LU/340/21/PL

Application for works to existing building including; Insertion of new windows and rooflights, infilling of windows, replacement of windows, addition of French doors and Juliette balcony, and replacement of roofs and new coping to flint wall. This application is in CIL Zone 4 and is zero rated as other development.

The Old Printworks 7 Arundel Road Littlehampton BN17 7BY

TA 1374 /04 rev. B

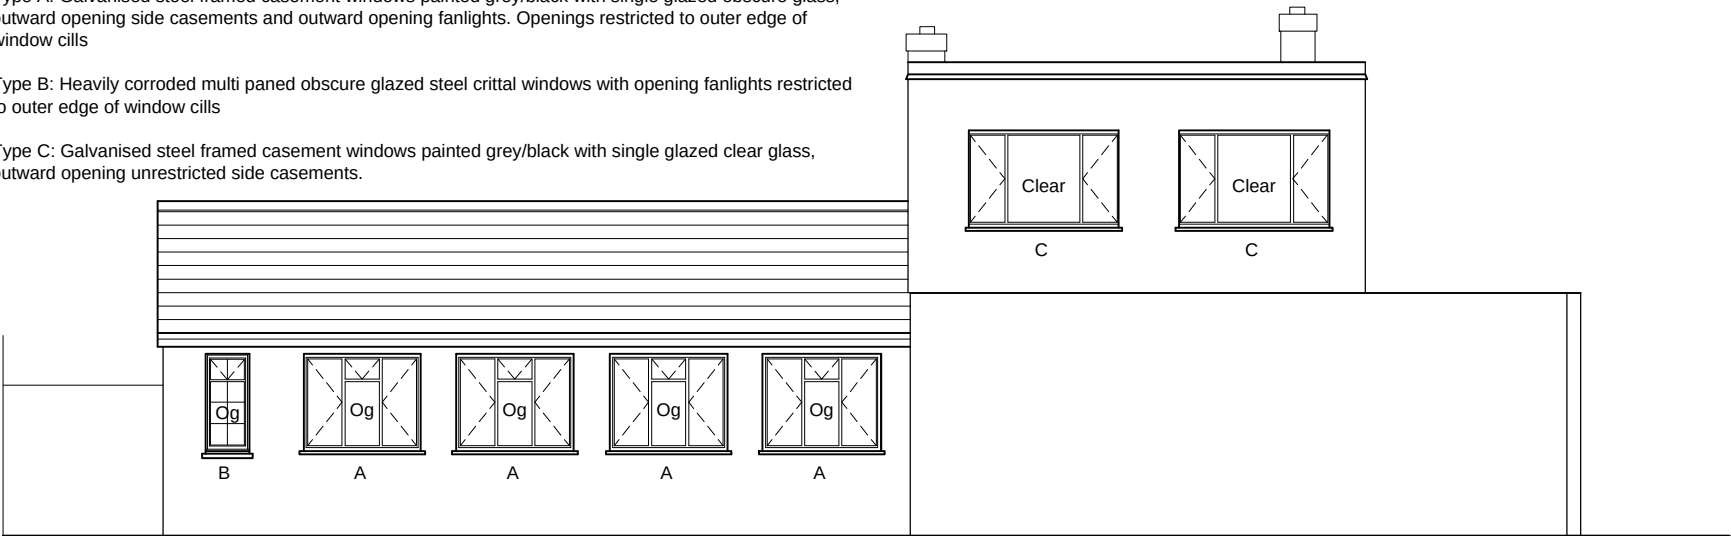
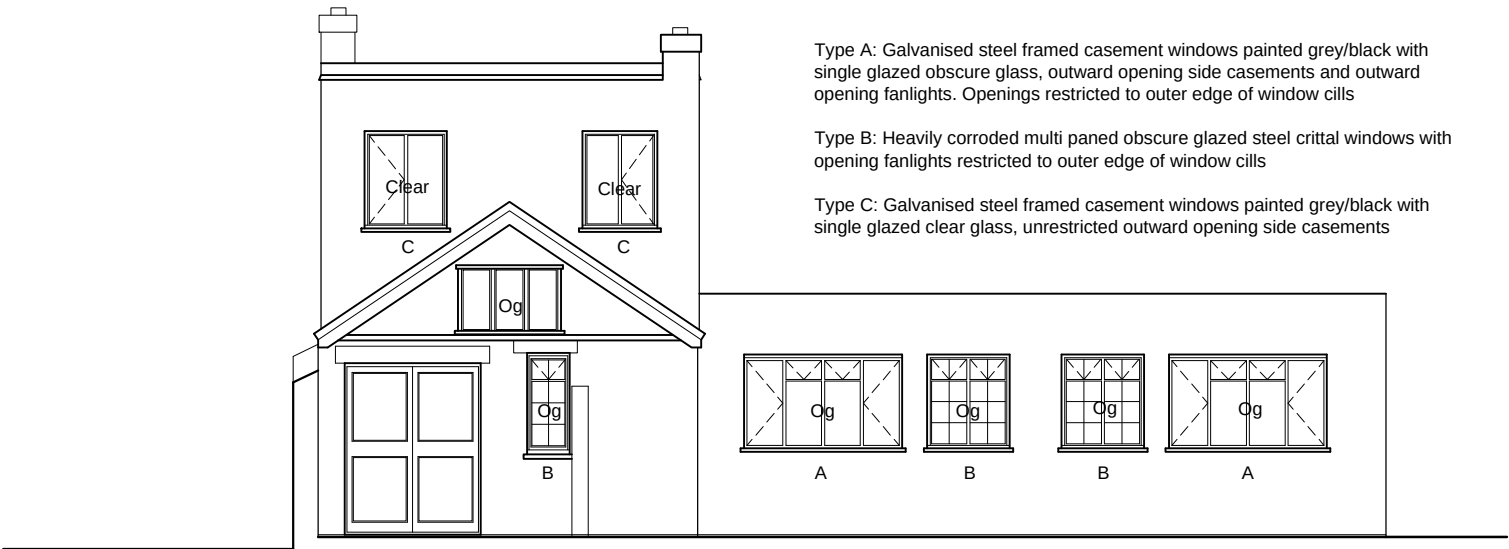
The method of opening/operation of the windows has changed: A review of the photographs/plans identified that the previous windows were black (or similar) painted steel Crittall framed casements, some of which were multi-paned, whereas the newly installed ones are aluminium dark grey powder coated single paned and top hung. Whilst it is a shame that the method of operation of the windows has changed, their simple appearance and dark colour will have a neutral impact.

TA 1374 / 12 rev. **B**

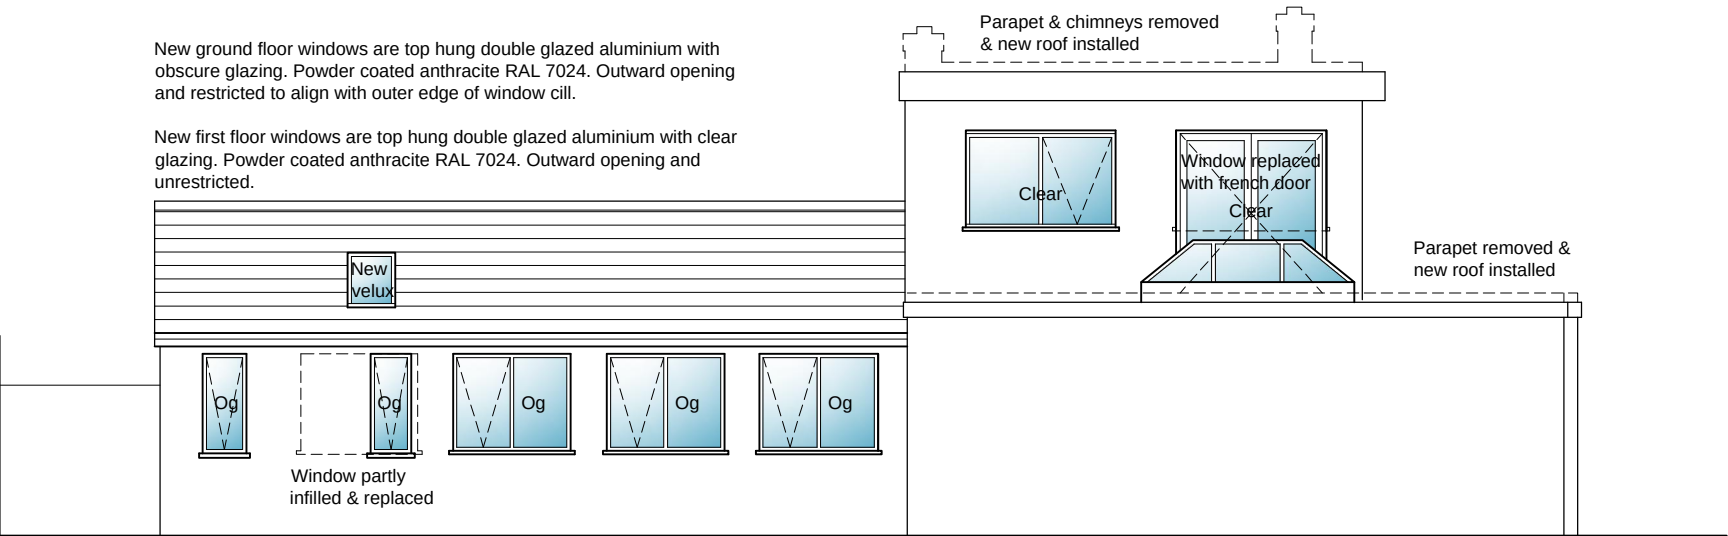
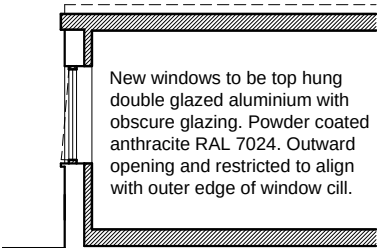
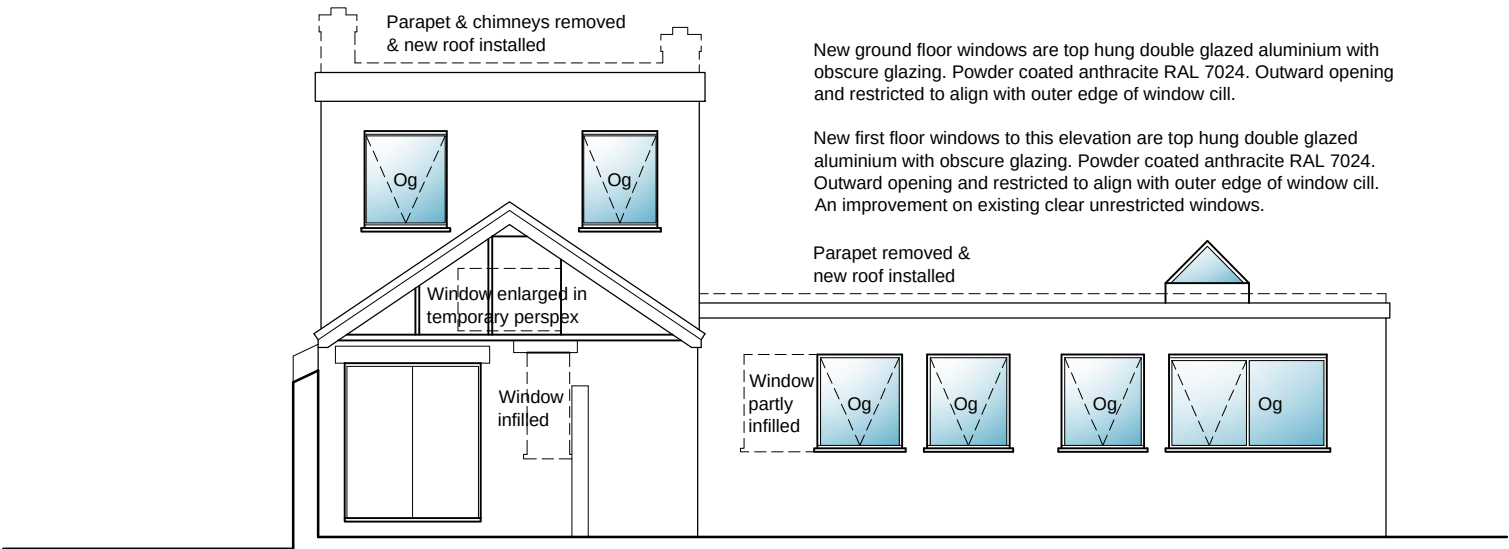
The repairs to the flint wall will also have a neutral impact – i.e. removing a poorly constructed concrete coping and replacing it with a flat black coping. Whilst not necessarily ideal, it will discretely cover the layer of bricks below it and appear better than the previous poor quality concrete version.
